PLANNING (LISTED BUILDING AND CONSERVATION AREAS) ACT 1990

LISTED BUILDING

Reference: H17-0260-26 **Date of Decision:** 11th May 2026
Applicant: Mr R Bright
Ivy House
Gosberton Bank
Gosberton
Spalding
PE11 4PB
Location: Ivy House Gosberton Bank Gosberton Spalding
Description: Proposed orangery to rear of dwelling including internal wall removal

Floor Plan

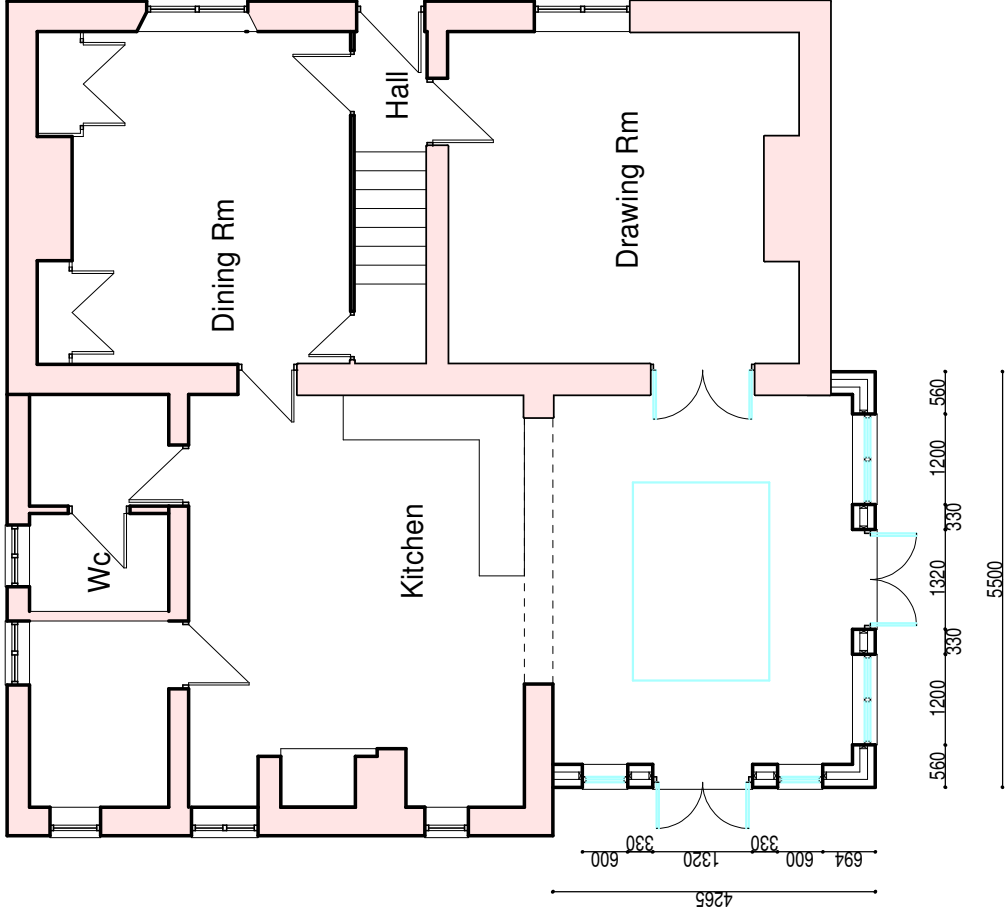
The proposal is considered to represent an incongruous feature, which relates poorly to the existing dwelling. The scale and positioning of the extension, in addition to the materials proposed and the demolition work detailed, is considered to give rise to unacceptable harm; the result of which would amount to less than substantial harm to the significance of the heritage asset.
